Exhibition of the Project Application for the Woollooware Bay Town Centre Stage 1 – Retail/Club Precinct, 461 Captain Cook Drive, Woollooware (MP 10_0230)

Transport for NSW (TfNSW) does have some comments in relation to the Director General's (DG's) Requirements presented in the Environmental Assessment.

TYPICAL SECTION - CAPTAIN COOK DRIVE

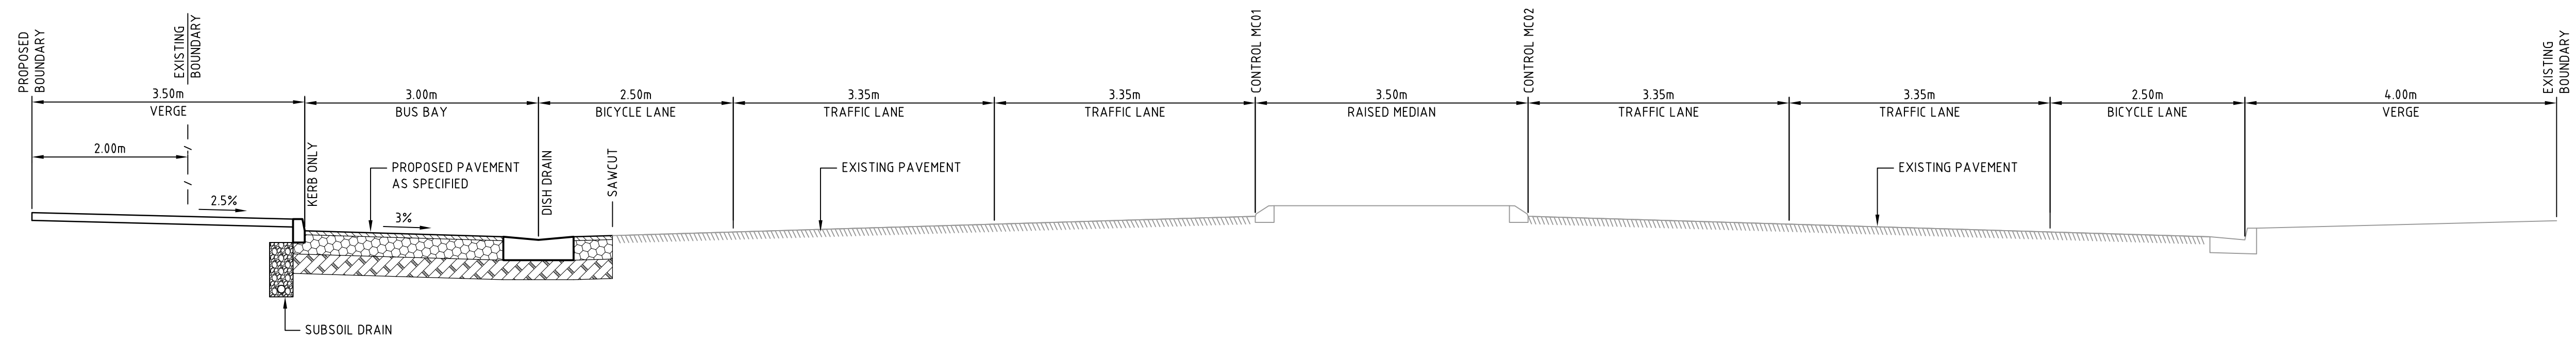
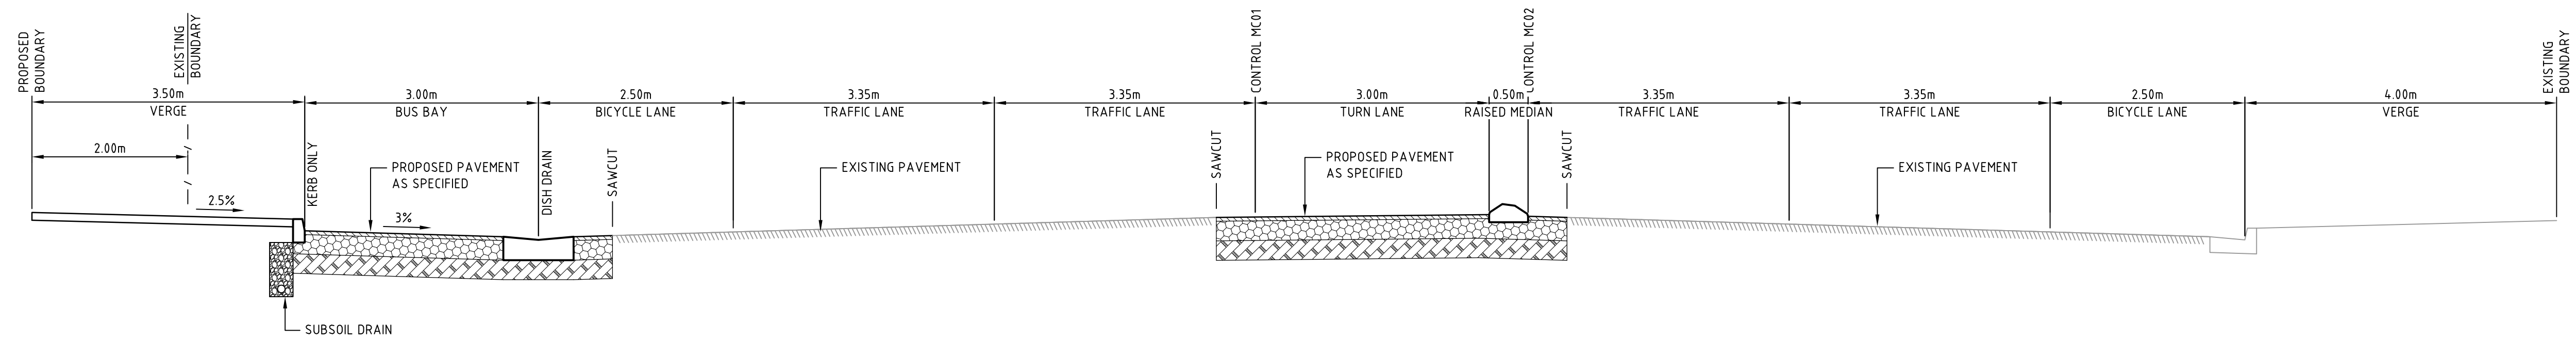
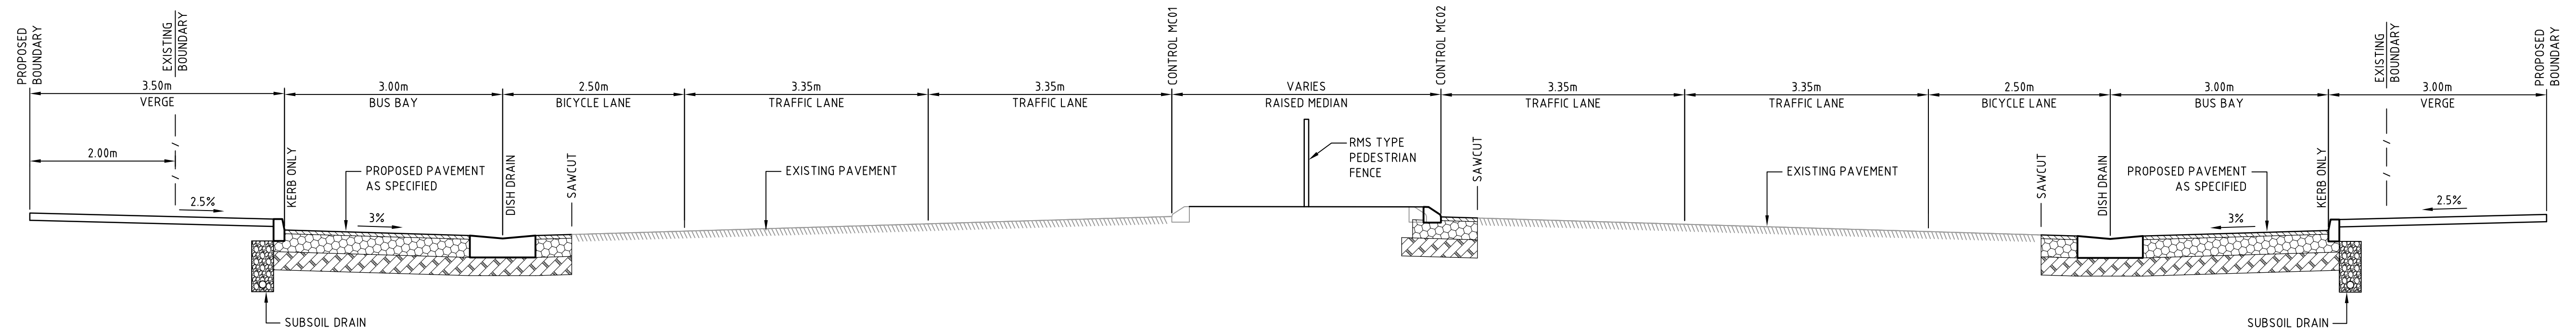
- The width of the proposed indented bus bays on Captain Cook Drive and Woollooware Road range from 2.5 metres to 3.0 metres. The width of these bus bays must be widened to have a minimum width of 3.5 metres. This would ensure that vehicles in adjoining travel lanes and cyclists in adjoining bicycle lanes are able to safely pass buses stopped in the bus bays. Adequate bus shelter should also be provided at proposed bus stops. The Environmental Assessment should also identify how many bus stops have been provided within each proposed bus bay.
